CITY OF ALBUQUERQUE

PLANNING DEPARTMENT – Development Review Services

RE: **Legacy Church – West Access Road**
7201 Central Avenue NW

File: **K10-D015**
PE Stamp Dated: 05-02-13

LEGACY CHURCH WEST ACCESS ROADWAY DRAINAGE PLAN

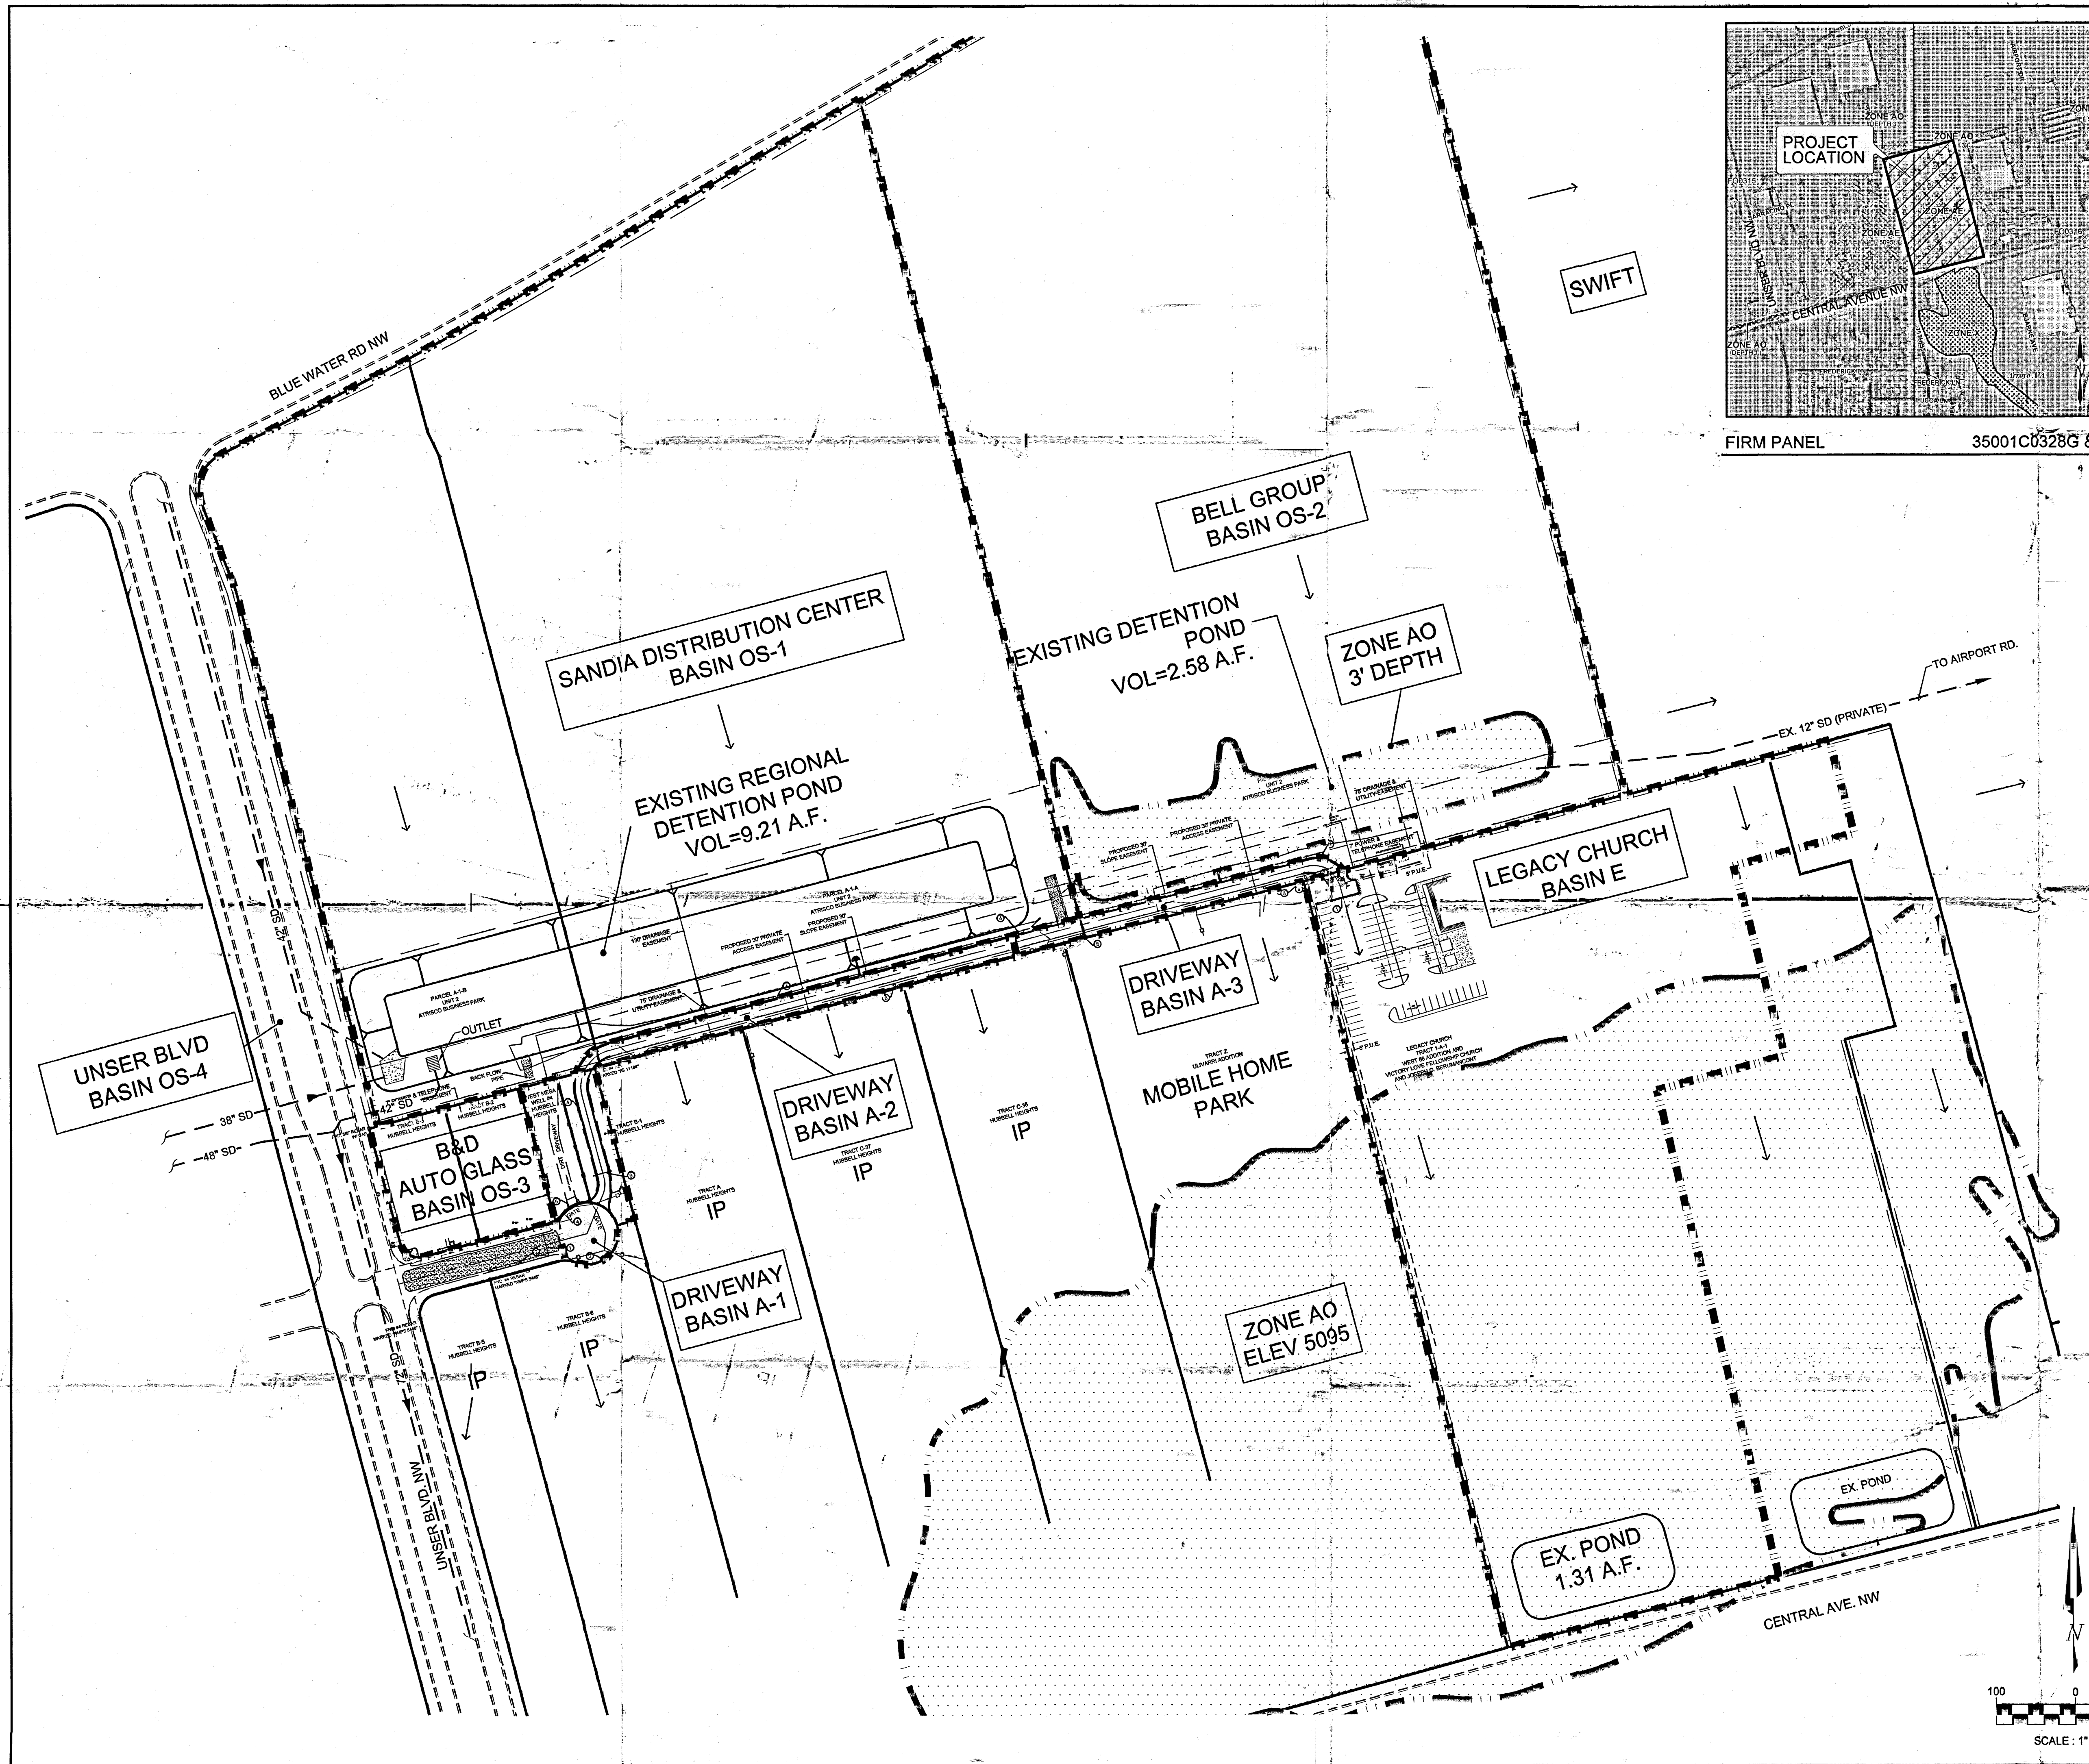
2. Show on the Grading Plan what existing and proposed pond volumes apply to the two affected ponds. Upon completion of the work, those pond volumes will need to be surveyed and certified to be in substantial compliance with this plan.

4. Page 1 of the report shows that the pond volume (in OS-1) was designed at 9.18 ac-ft, and expanded to 12.19 ac-ft. What is the source of this information? Does your current topo-survey support those values?

TITLE:
LEGACY CHURCH
WEST ACCESS ROADWAY SITE PLAN

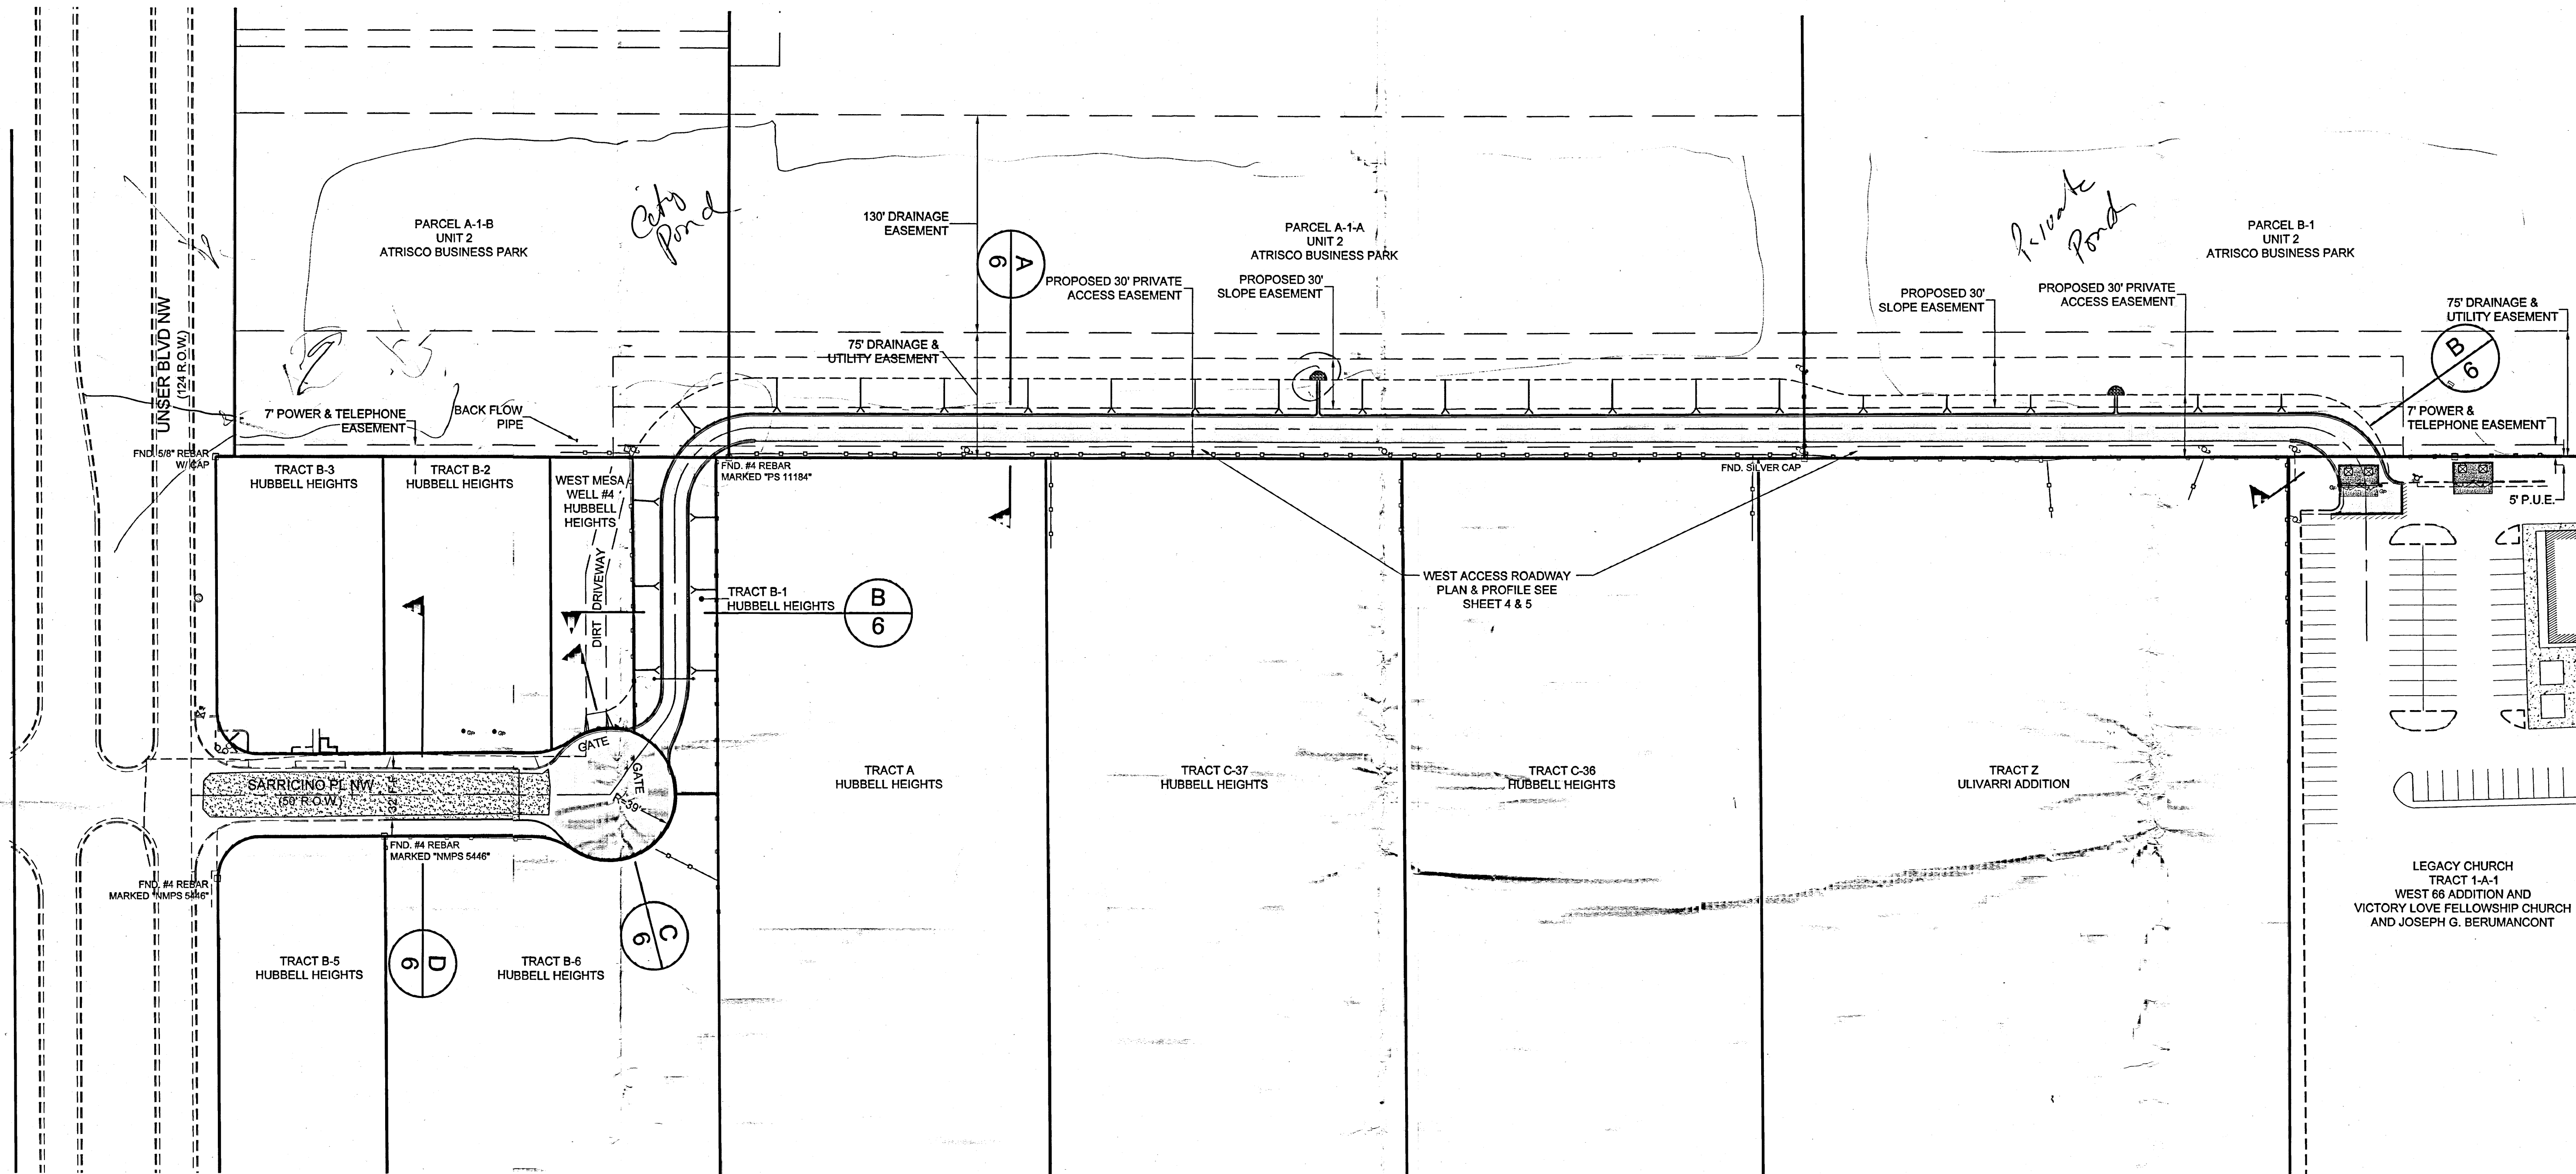
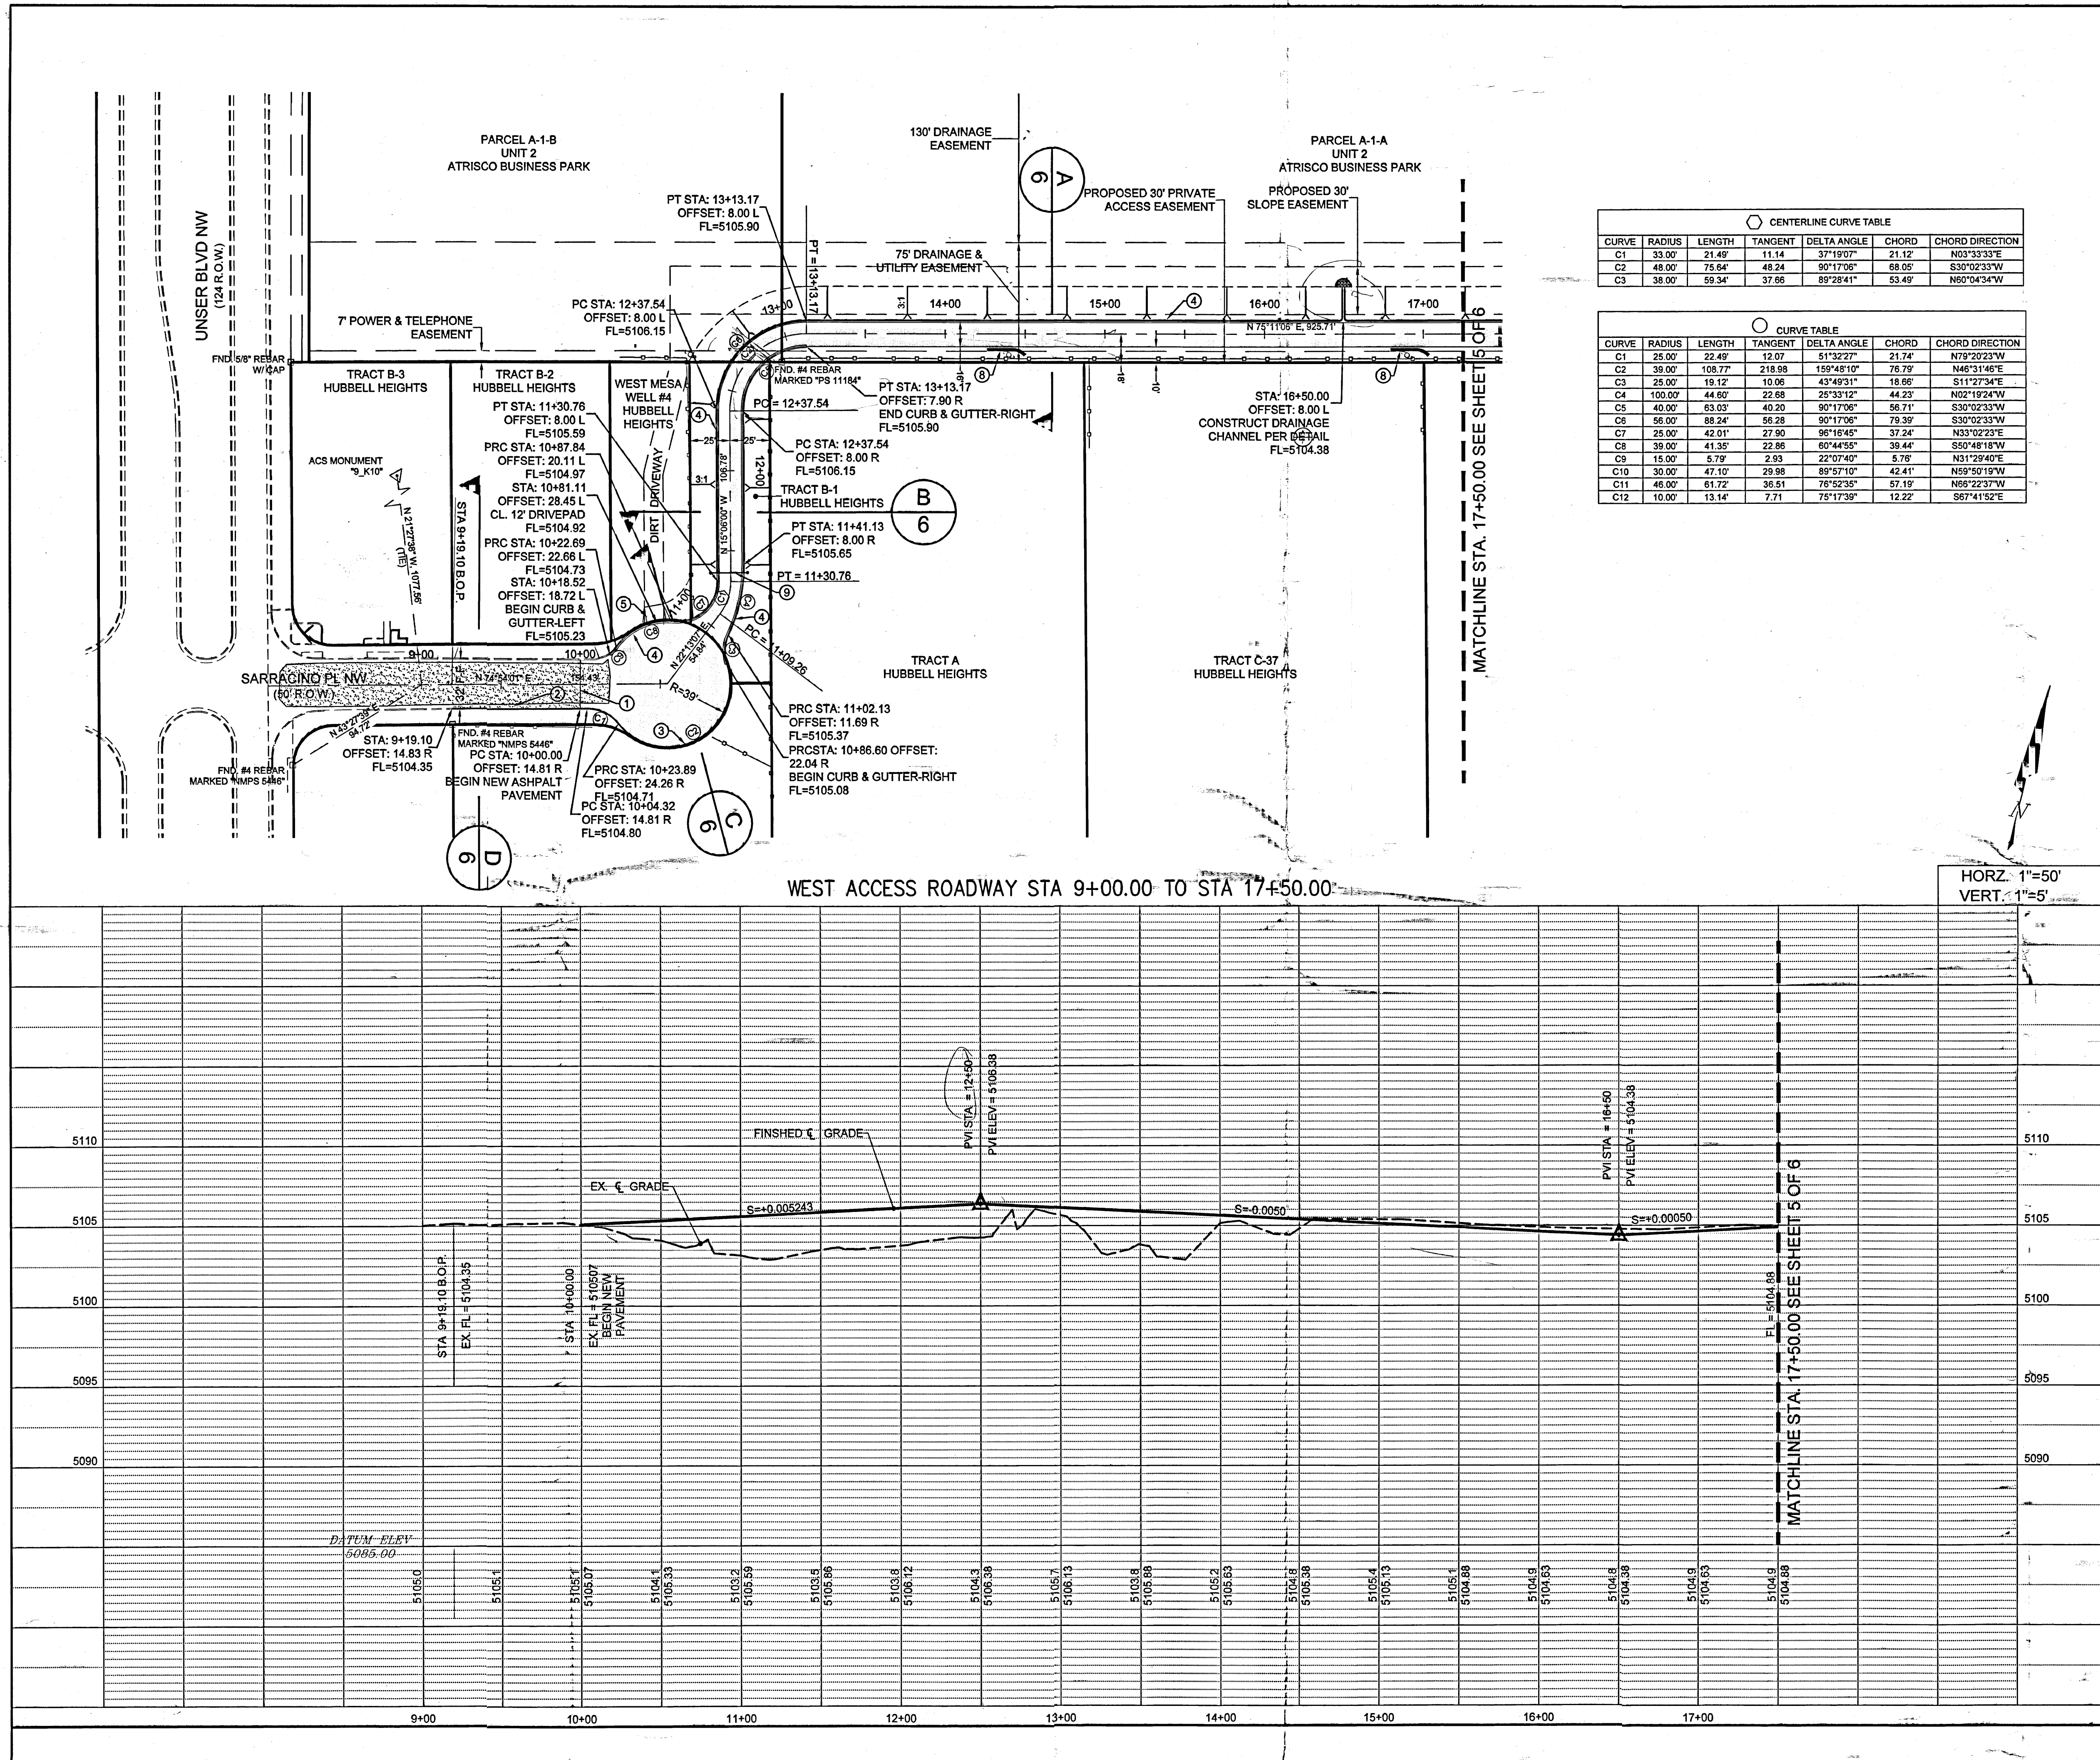
1. The “Private Access Road” constructed within the Public Utility and Drainage and Easement on the Sandia Distributing lots is unacceptable for hydrology. This layout will require a plat revision to change the shape of the Public Drainage Easement(s) to exclude the area of the Private Access Easement and roadway. As an alternative, could the access roadway be built on the private parcels, south of the southern boundary of the ponds?

6. Paving of the cul-de-sac on Sarracino Place will require a Work Order approved by the City's Design Review Committee (DRC).
7. Reconfiguration of the Public Detention Pond will also require a Work Order.

8. The grading and drainage plan for Sandia Distribution Center shows a maintenance access ramp on the south side of the pond, which is not on the survey, and may needed to be added, or relocated, in conjunction with the proposed roadway.
